Re: Application no: 2016/0068

This application referred above is for an extension of time and a tripling of vehicle movements on and off the site under remediation.

Proposed Access & Highway Improvements

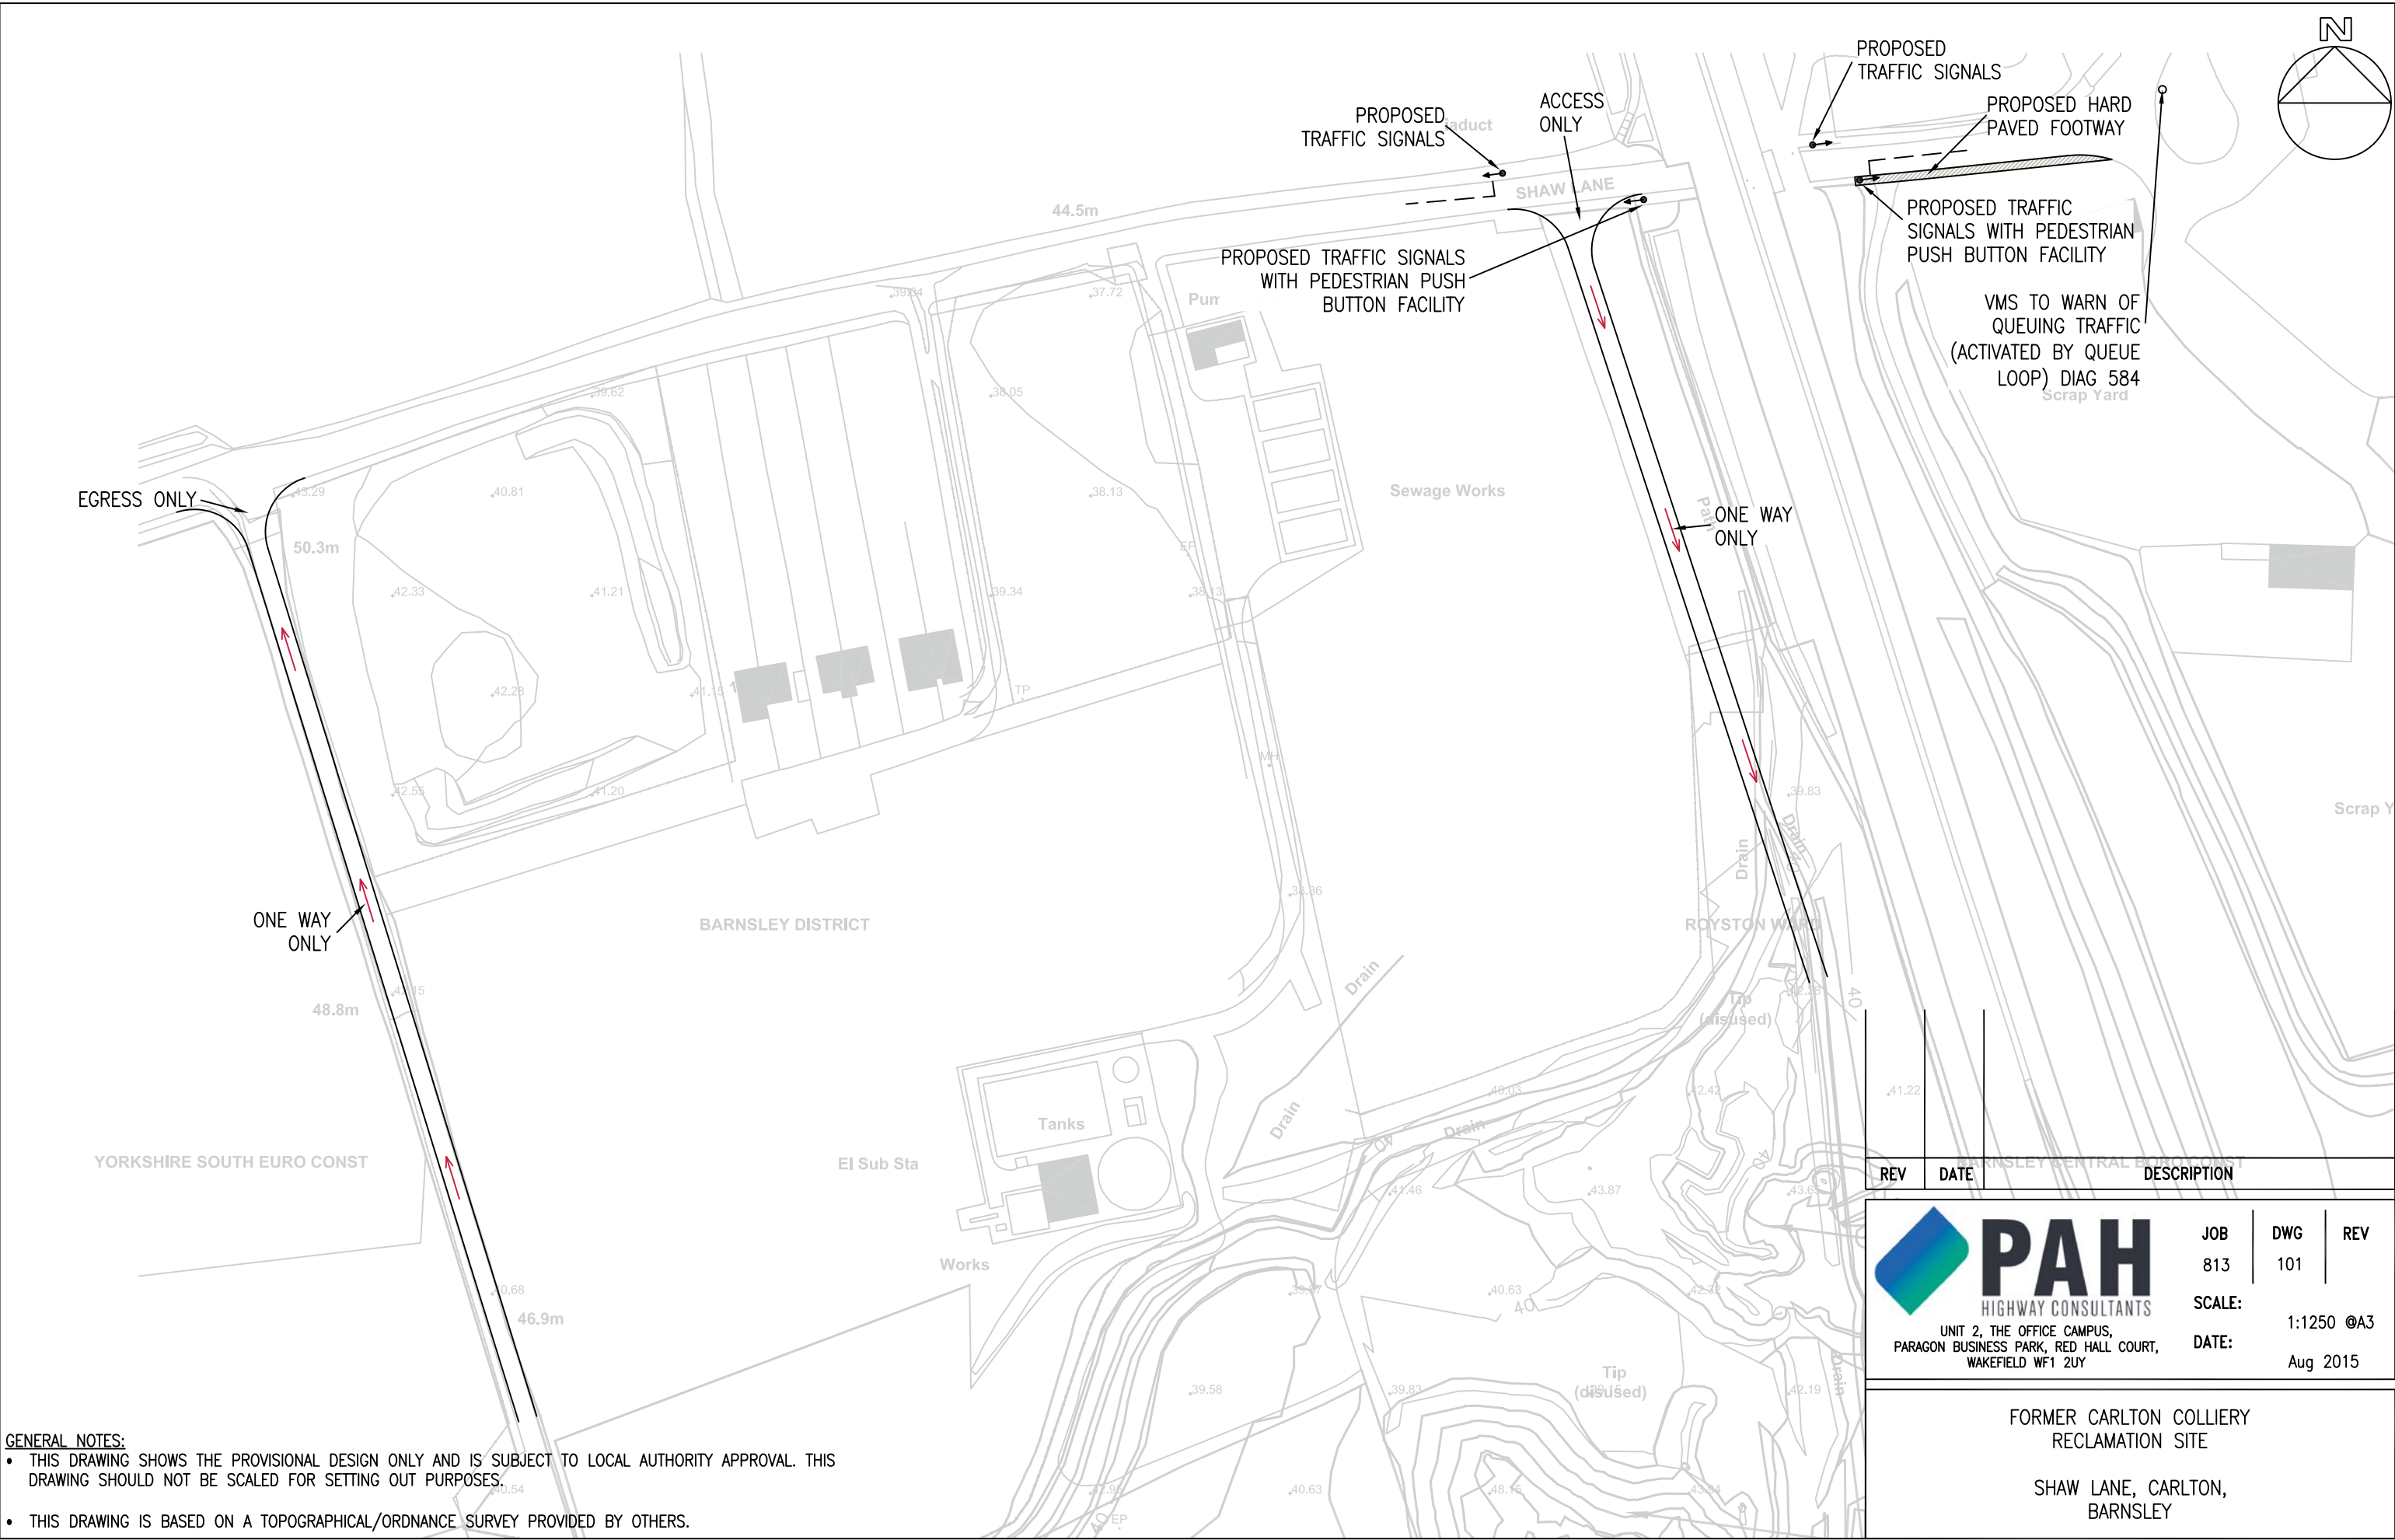
The proposed traffic lights at the bridge where the proposed new entrance to the site is intended, will surely cause a further problem with traffic flow on this lane as I can foresee standing traffic queuing from the proposed new traffic lights up to the houses numbers 111-101 especially as the proposal includes a traffic light facility for pedestrians to traverse under the railway bridge. I can also foresee a problem with queuing traffic at the other side

of the railway bridge up to and round the first bend where there are accesses to the scrap yards on both sides of the road with a further junction on Boulderbridge Lane also on the next bend. Many heavy goods vehicles are already using that access to the aluminium recycling plant.

Increased traffic on this lane will also cause more problems for residents of 111-101 who have difficulty exiting their concealed access track already owing to the speed of oncoming traffic.
